05 December 2019

**SSD 10114- MIXED USE DEVELOPMENT, LOT 469 IN DP 821073; LOTS 2 -7 IN DP 14761;  
LOT 1 DP 1235203, 26-32 MANN STREET, GOSFORD**

Transport for NSW have reviewed the Environmental Impact Statement (EIS) prepared by Urbis dated September 2019, including Appendix K, Transport Impact Assessment (TIA), prepared by GTA Consultants dated 27 September 2019, and the submitted SIDRA Intersection files.

Figure 3.7: Existing AM / PM network peak hour traffic volumes

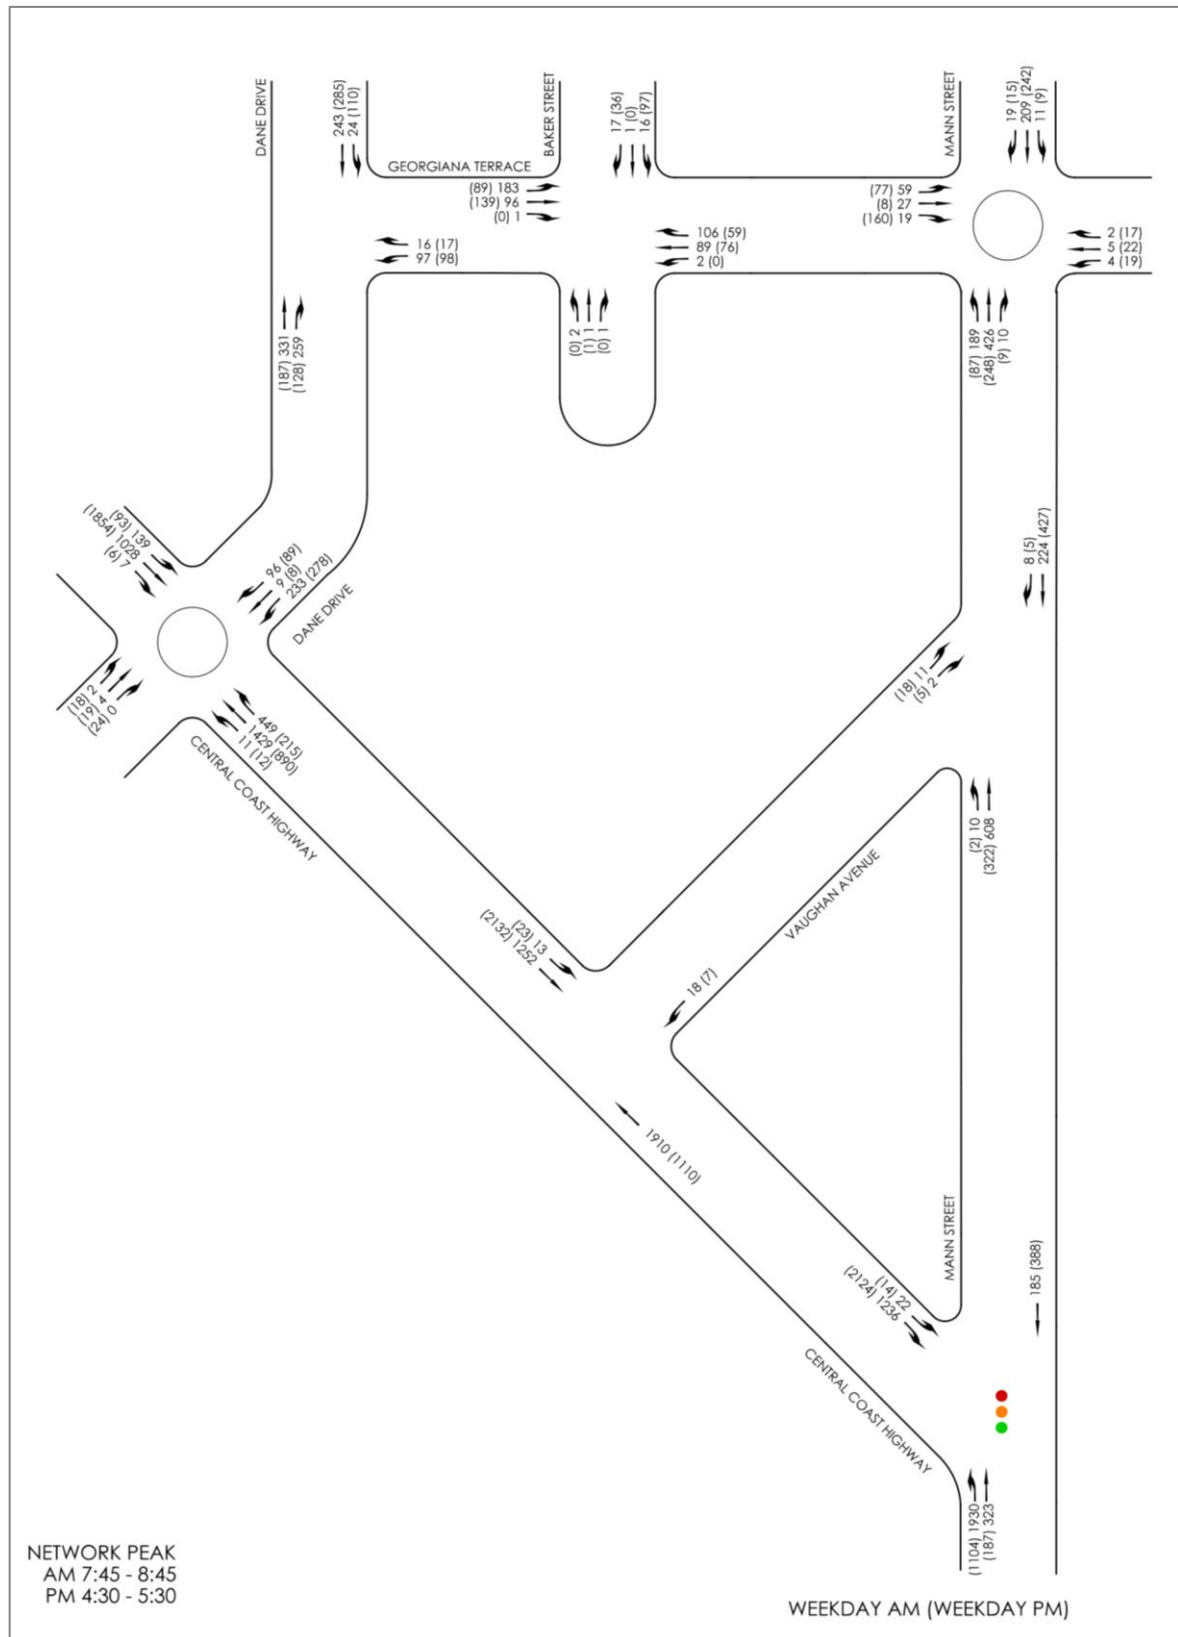
- The TIA has assumed a trip rate of 0.4 trips per bed for the hotel, however the author has not described where this trip rate has been sourced from. The source for the hotel trip rate should be provided to support these numbers.
- The SIDRA assessment has been undertaken so that all intersections operate individually. There are a number of closely spaced intersections within the study area, and the network traffic impacts have not been assessed. Due to proximity of these intersections, it is likely that impacts are expected on these intersections.

- It is clear that under existing conditions and under the 2022 and 2032 scenarios, the intersection of Central Coast Highway / Dane Drive experiences significant delays and poor level of service as outlined in the report. The trip distribution assumptions state that it expects 30% of traffic generated by the site to come from the west. However, there appears to be significant development to the west, including industrial, retail, an entertainment ground and other traffic generating developments. Furthermore, based on existing travel patterns significant traffic volumes utilise this intersection, which in turn would suggest that additional traffic on the network would also utilise this intersection as a priority. Additional traffic at this intersection is likely to further exacerbate the existing

- The intersection of Mann Street / Central Coast highway is expected to operate at acceptable levels of service in 2022 during the AM and PM peak hours, however the queue lengths along the north western leg of Mann Street extend up to around 467m in the PM peak. This would extend passed the intersection of Central Coast Highway / Vaughn Avenue, which could block vehicles exiting from the development and cause queues to back up along Vaughn Street. These queues could also back up to the intersection of Central Coast Highway / Dane Drive, further exacerbating the poor performance of this intersection. (The signalised pedestrian crossing which may also add further delay which hasn't been considered). This issue is further exacerbated in 2032, where queues also extend along the southern leg of the intersection and could extend passed the signalised pedestrian crossing and up to Albany Street.

Therefore clarification for not assessing the network using a networked SIDRA model is required. Alternatively, a networked SIDRA assessment is recommended.

Therefore further clarification for the trip distribution assumptions should be provided.

Therefore, it is recommended to address these issues and impact on traffic network as a result of the development.

Figure 4.1: Proposed entry/ exit arrangements ground level

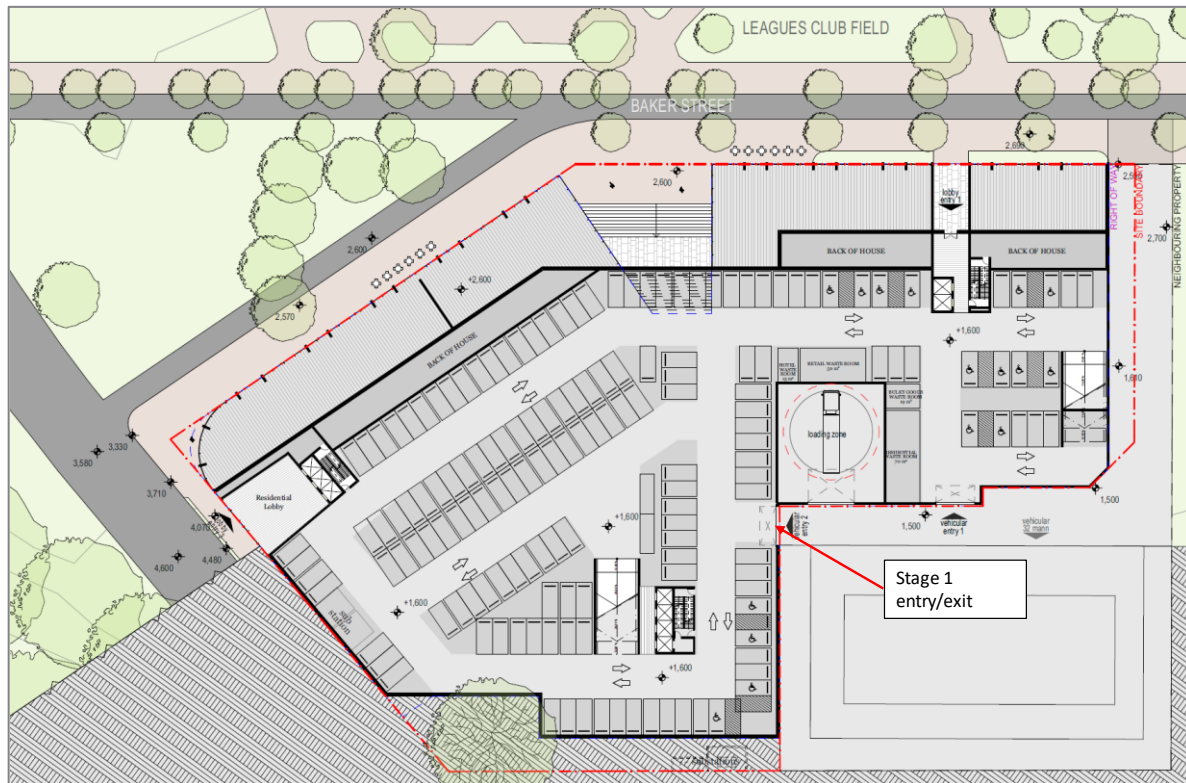
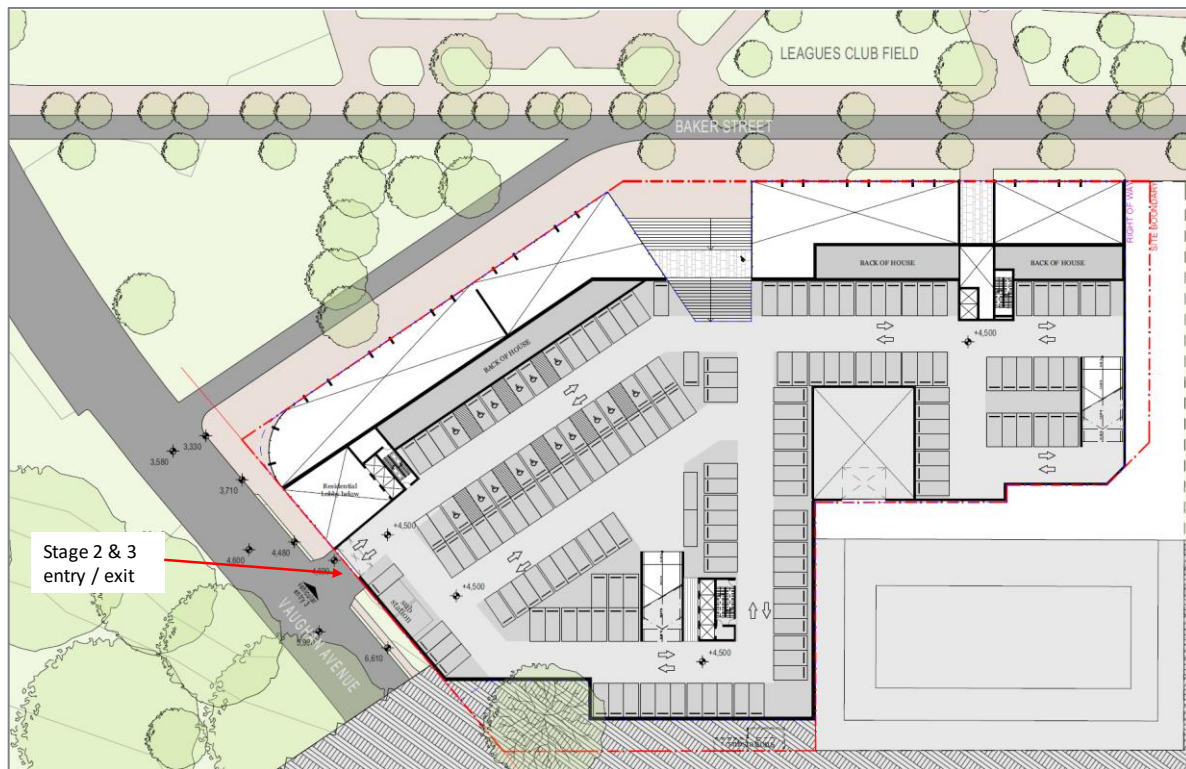
- Roads and Maritime has no proposal that requires any part of the property.
- The stage 2 and 3 car park entry / exit point is expected to cater for approximately 350 parking spaces. It is not clear at this stage how the car park entry / exit is going to be managed (ie through boom gates, roller doors, or unsecured). It is expected that a significant number of trips during the peak hour may use this driveway access, particularly in the PM peak when residents are returning home from work for example. It is recommended to undertake an assessment of the expected queues at this driveway, and appropriate management measures.
